KIRKLEES METROPOLITAN COUNCIL INVESTMENT & REGENERATION SERVICE

DELEGATED DECISION TO DETERMINE APPLICATIONS FOR LISTED BUILDING CONSENT

Reference No:	2026/65/90119/W
Site Address:	26, Swallow Lane, Golcar, Huddersfield, HD7 4LU
Description:	Listed Building Consent for installation of replacement door and frame (within a Conservation Area)
Recommending Officer:	Joshua Merriman

Officer Report – 2026/90119

TITLE: FLAMEBREAK CORE
CROSS SECTION

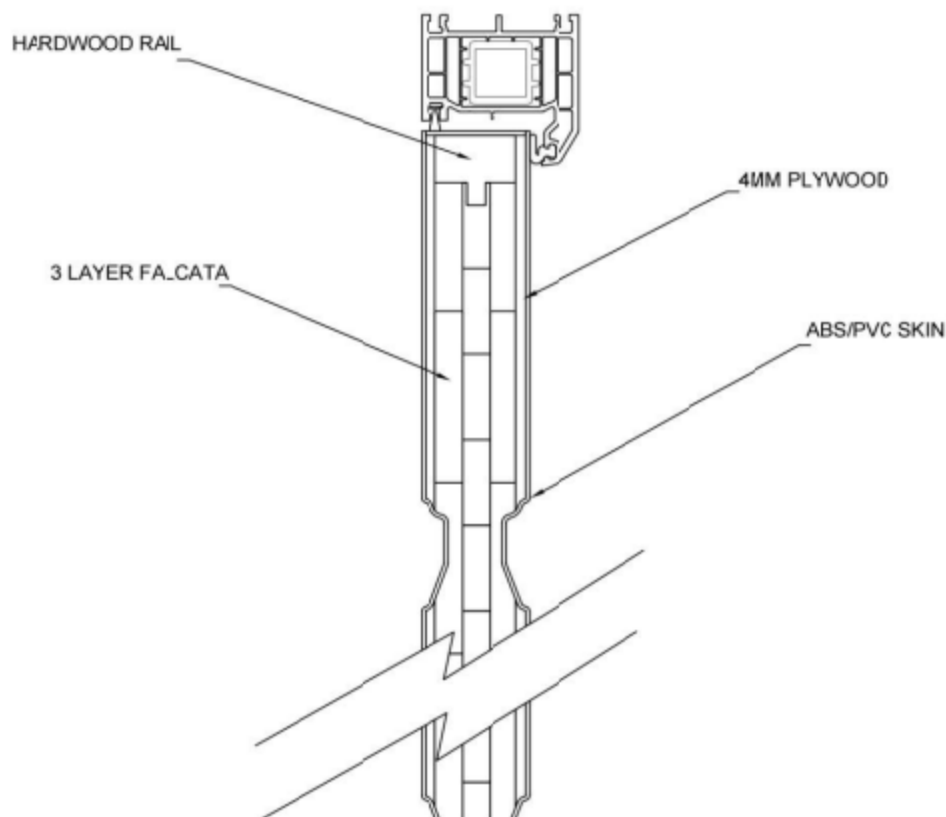
The changes to the property include replacing the existing timber front door with a composite door and modifying the frame of the front elevation door to also reflect a composite finish. KC Conservation & Design have been consulted and object to the use of a composite replacement door on a Grade II Listed Building.

The replacement door is a composite material and would be at odds with the historical authenticity and visual integrity of the building. Listed buildings are protected to specifically to preserve their original features, materials and craftsmanship. Due to the surface texture, proportions of panelling there would be a noticeable visual difference. In replacing the door the works would detract within the street scene and from the character of the conservation area. The use of modern materials would appear unsympathetic and detract from the character and appearance of the building undermining the special historic interest contrary to Policies LP1, LP2, LP24, and LP35 of the Kirklees Local Plan, and Policies within Chapter 12 and 16 of the National Planning Policy Framework.

1. The replacement of the door with a composite door, because of its modern materials, detailing and appearance would fail to preserve the character and appearance of the listed building. The development would result in the loss of traditional fabric and would introduce an incongruous feature that is not sympathetic to the building's historic significance and would also detract from the street scene. As such the

KC Conservation & Design (Informal) – The use of a composite door on a Listed Building is unacceptable as it significantly harms the historic character of the building and surrounding Conservation Area. Only a matching replacement (timber) would be considered acceptable in this case.
